RFI #: 49
 Date: 2/3/2012
 Job: EB-02 Keller Springs Lofts
 Phone: 877-777-5115

Subject: thickened beam wall rebar requirements

RFI #: 59
 Date: 2/21/2012
 Job: EB-02 Keller Springs Lofts
 Phone: 877-777-5115

RFI #: 172
 Date: 7/11/2012
 Job: EB-02 Keller Springs Lofts
 Phone: 877-777-5115

SECTION 3
SCALE: 3/4"=1'-0"

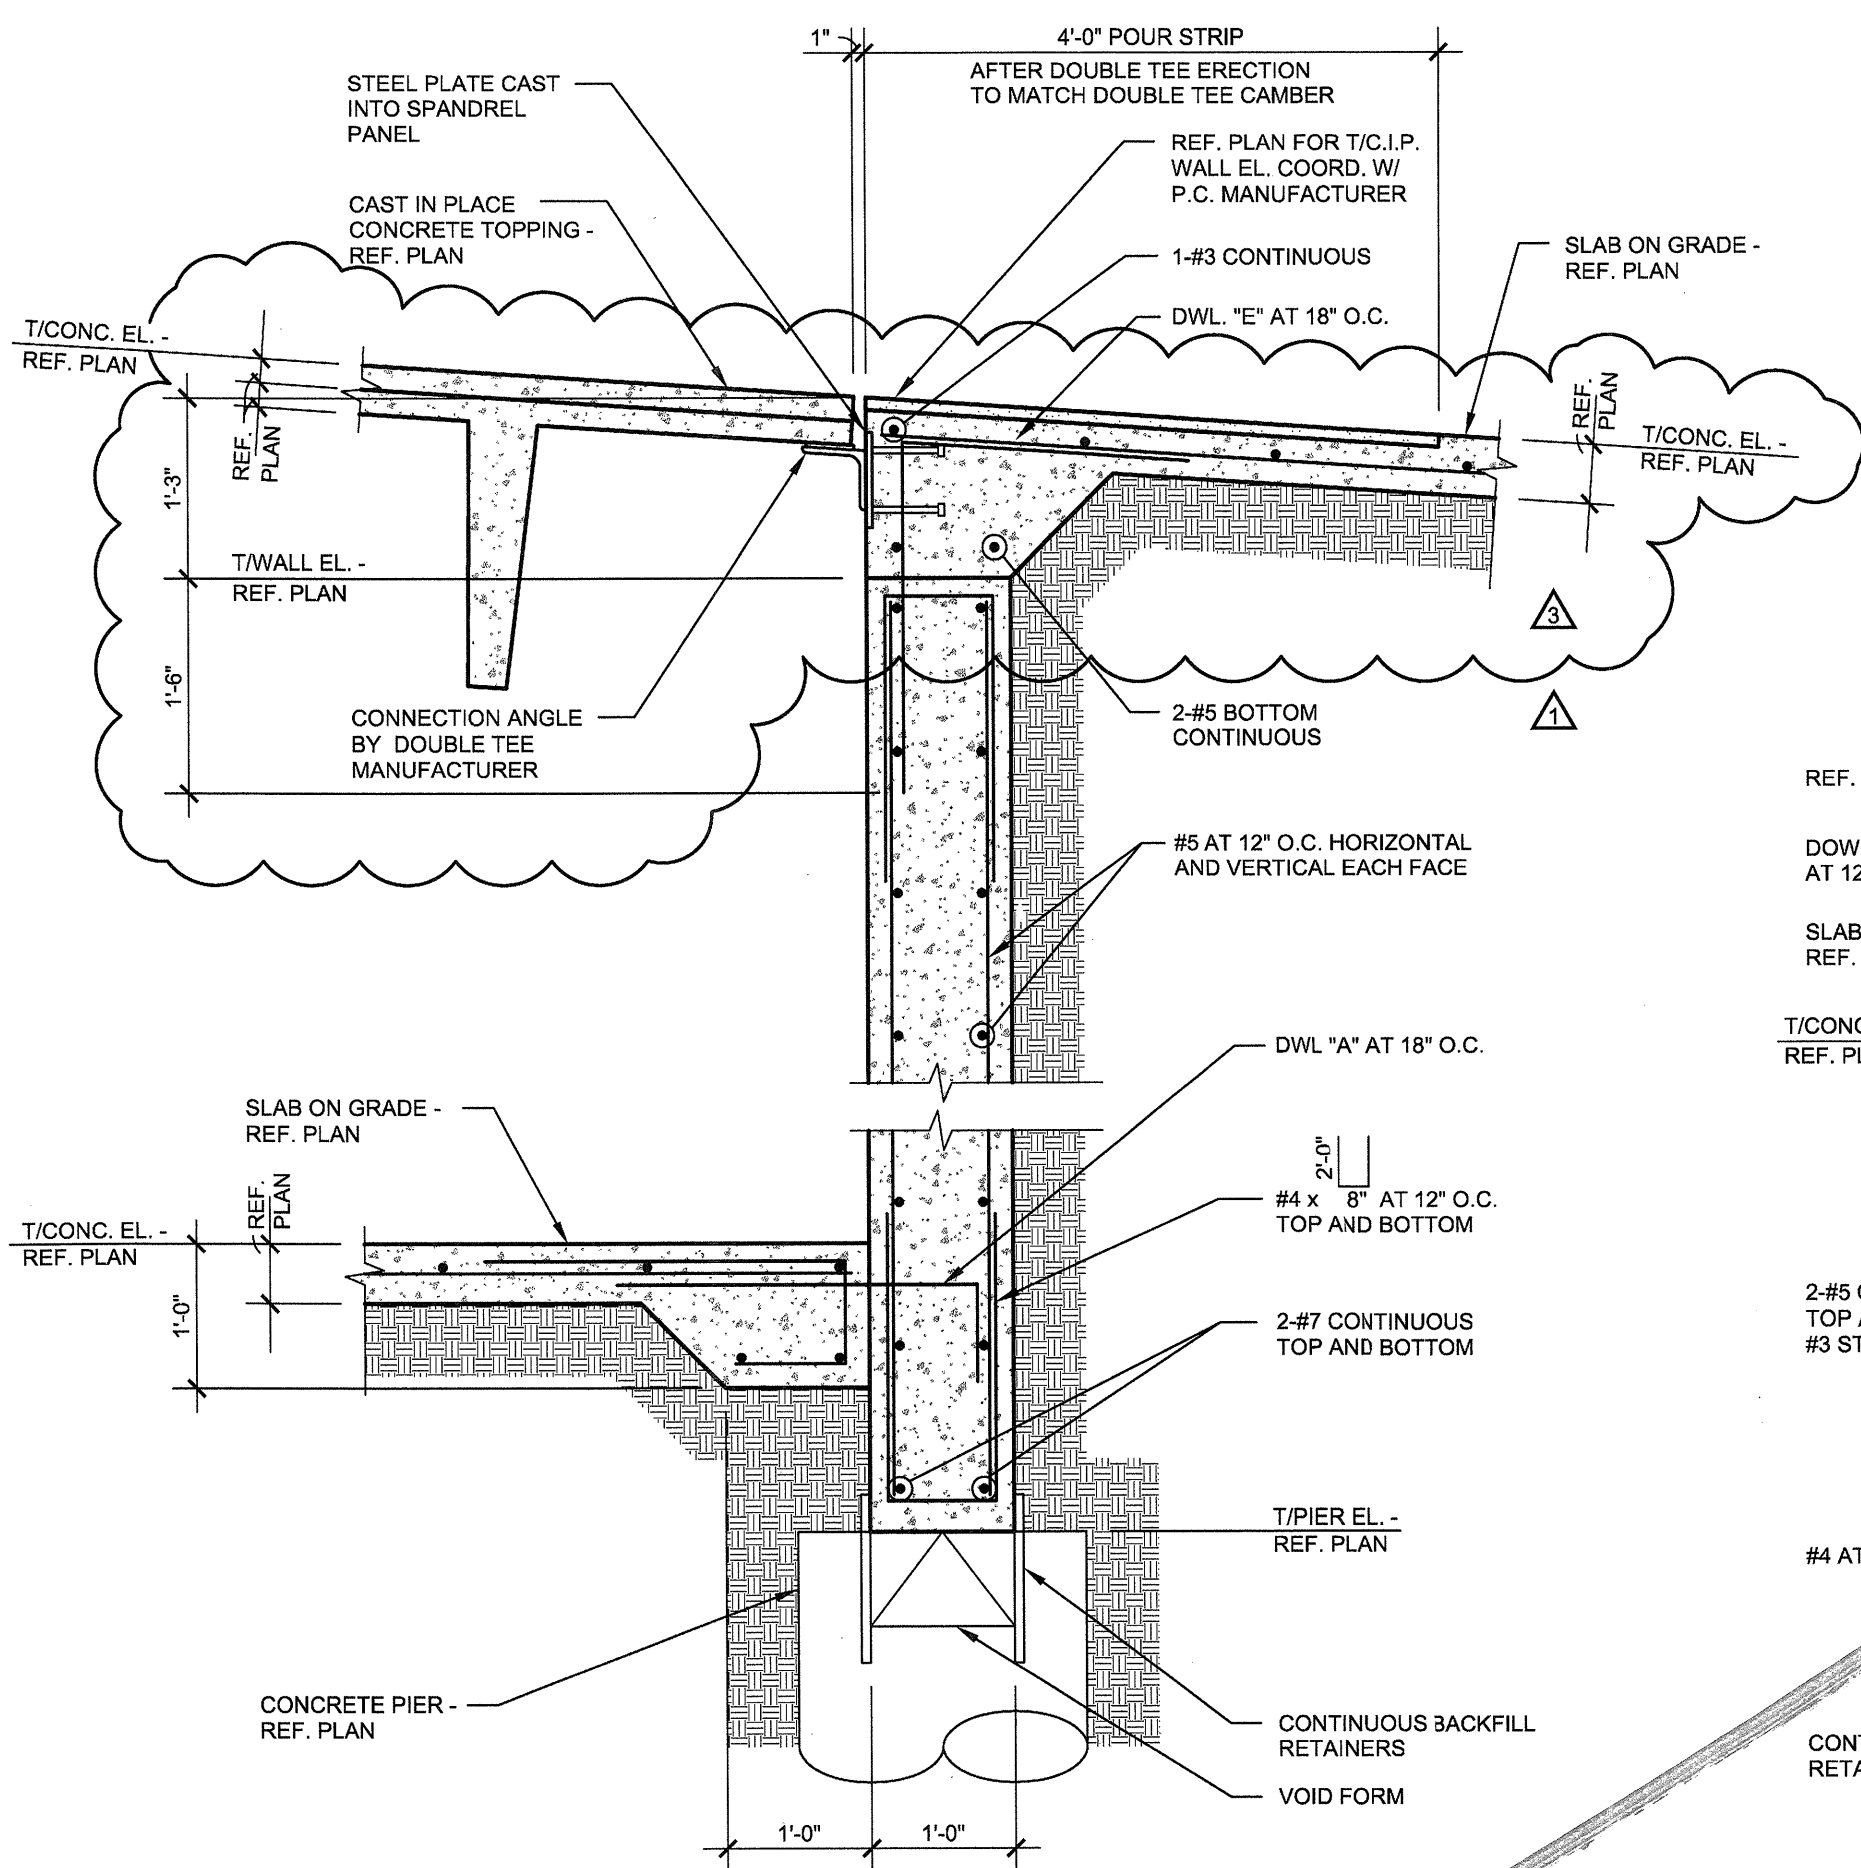
Request:
 At the intersection of Grid line 2 and Grid line B is a 6' section of thickened beam wall. 3/SG3.02 is the cut-thru of this wall, but does not show this thickened area for rebar requirements. Because of panel limitations we will have to make the width of the beam 16" instead of 16". Therefore, this thickened area of the wall will be 6'-0" X 16". Please advise and detail the proper steel reinforcing requirements see attachments.

Reference the attached detail for beam width and reinforcement detailing. If you have questions or require additional information regarding this matter, please do not hesitate to contact us.
